From: Joanne Needham <joanne.needham@spab.org.uk>
Sent: 07 September 2022 15:19
To: Planning
Subject: FAO Adrian Dowd Re: 3/2022/0727 - Lower Reaps Farm, Whinney Lane, Mellor, BB2 7EL - SPAB Response

Application ref: 3/2022/0727

Address: Lower Reaps Farm, Whinney Lane, Mellor, BB2 7EL

Proposal: Proposed refurbishment of existing farmhouse, conversion of existing attached and detached barns to create three new dwellings, conversion of outbuildings for associated residential use and external works.

Drawing Title  
Proposed Barn  
Floor Plans and Elevations

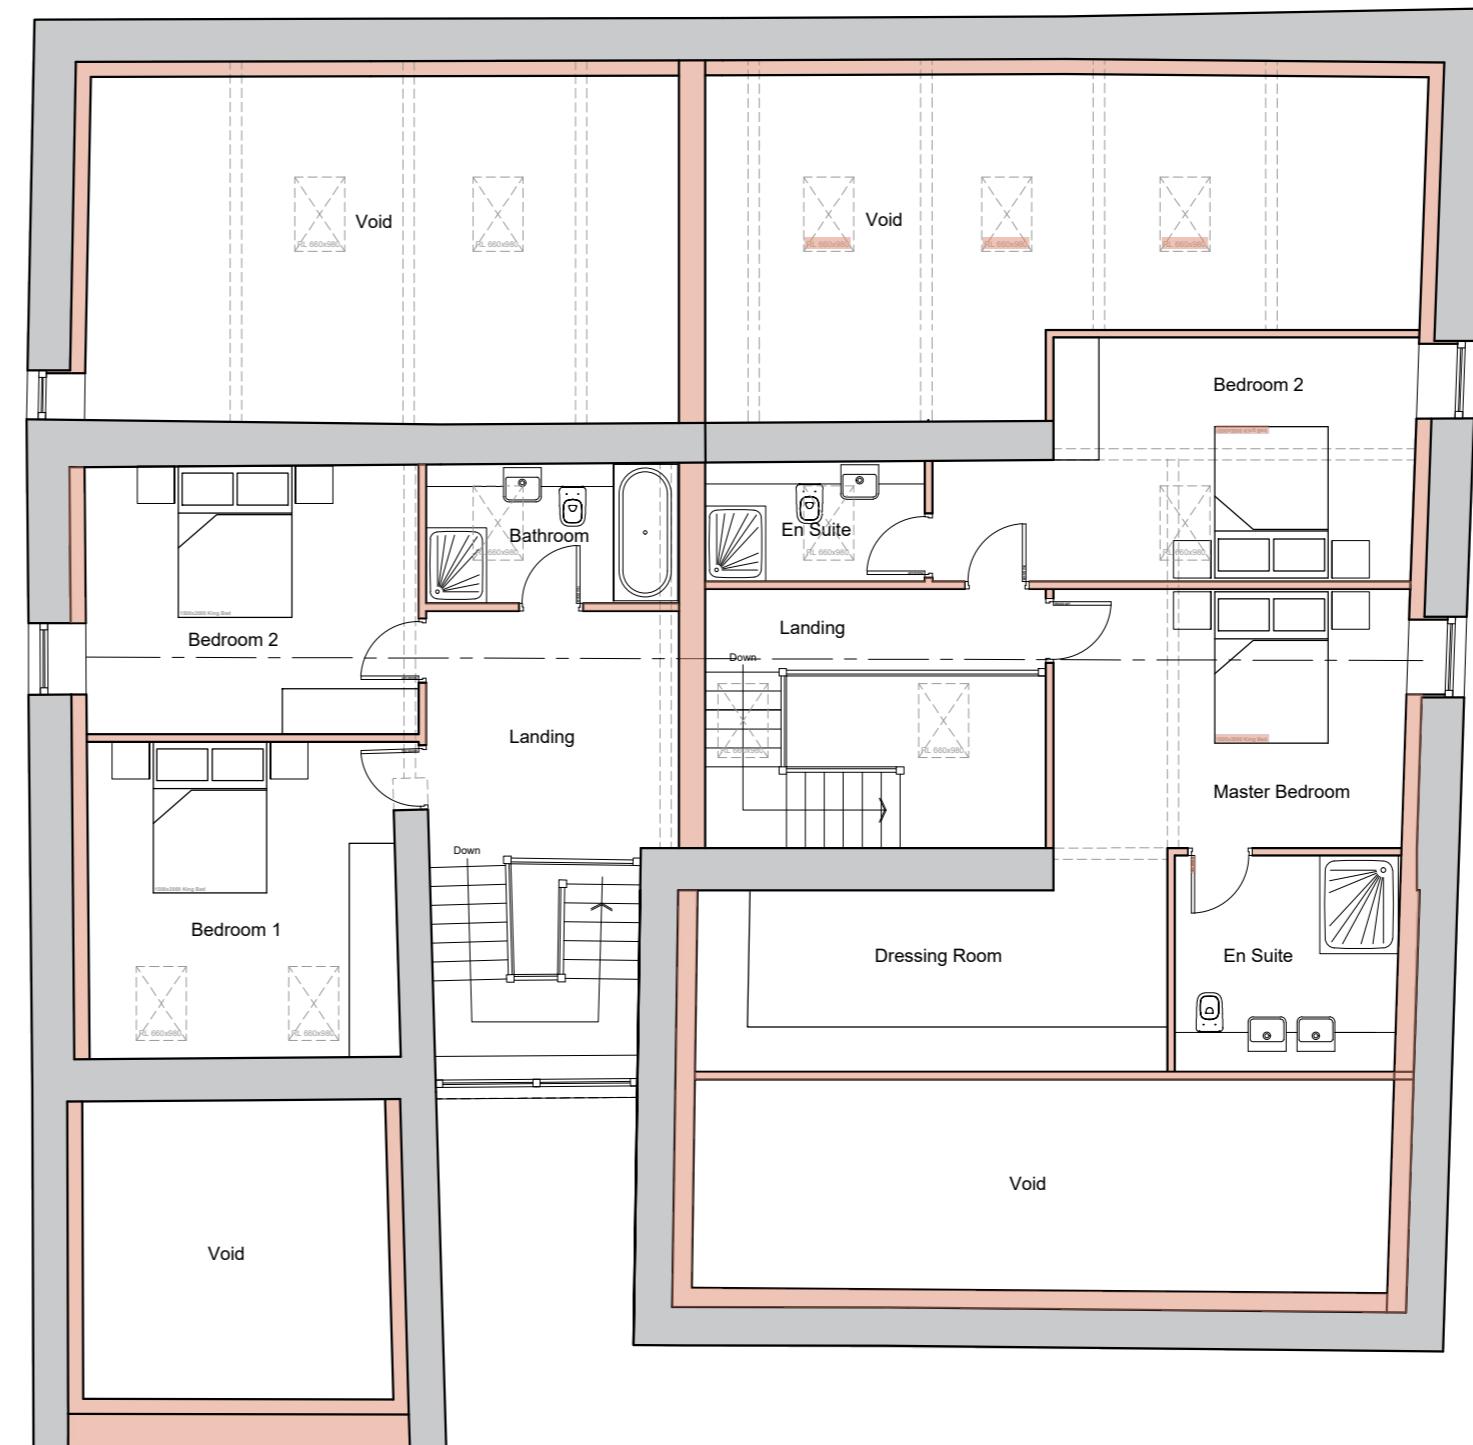
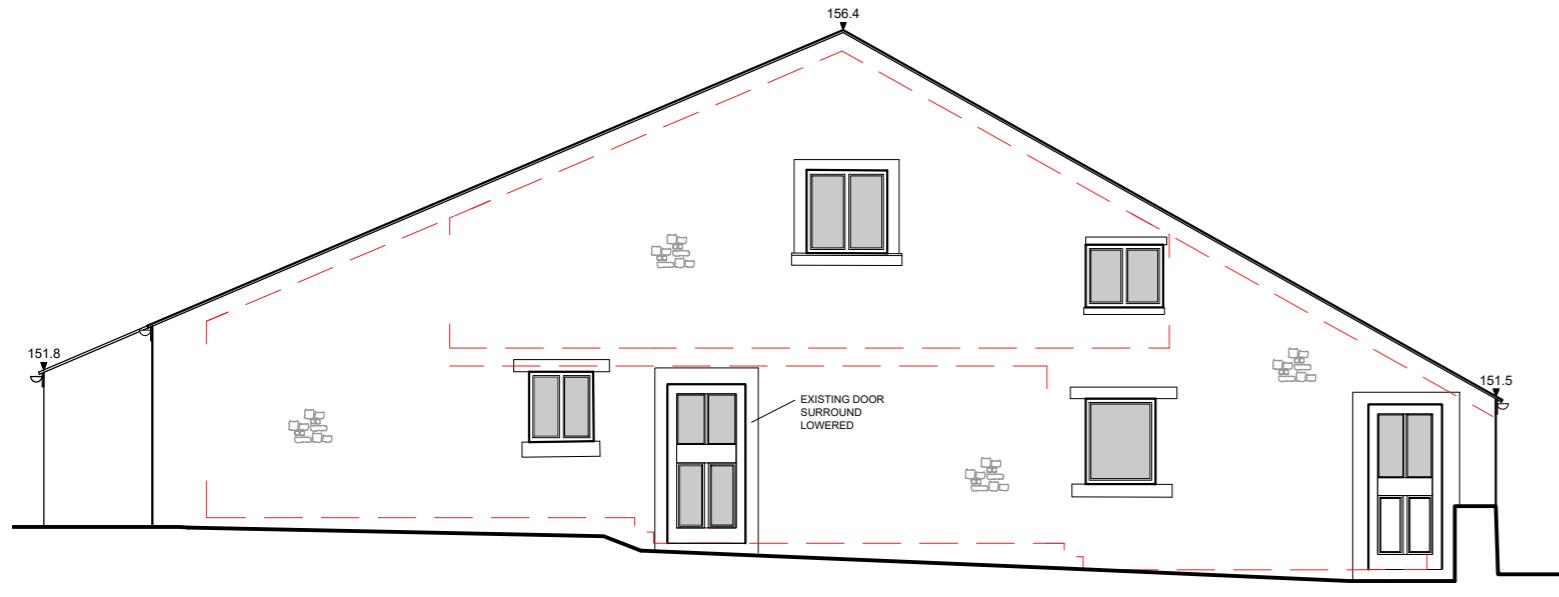
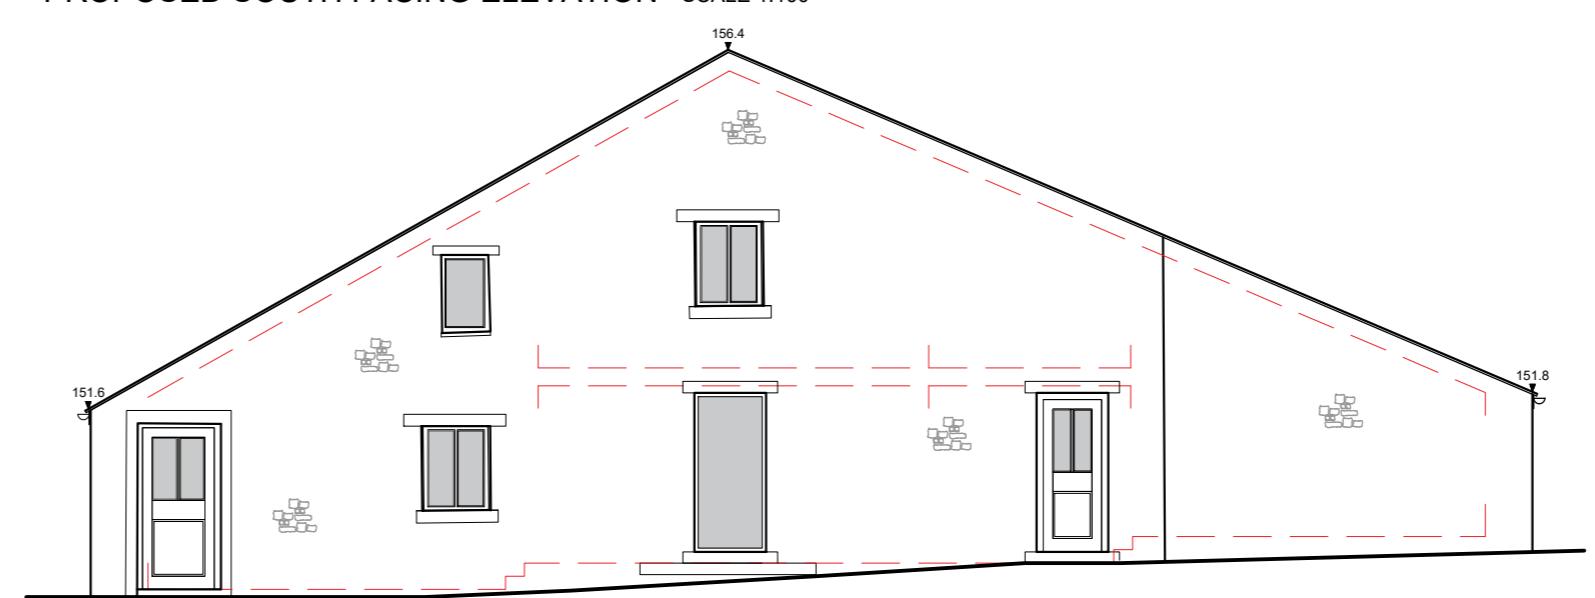
The proposals for the agricultural buildings are considered too invasive (demolition/alterations of walls, no of rooflights, new apertures, subdivision of spaces etc) and that their interest, significance, and agricultural character would be harmed, and in turn, harm the principal building (the Farmhouse), the overall farmstead and its setting.
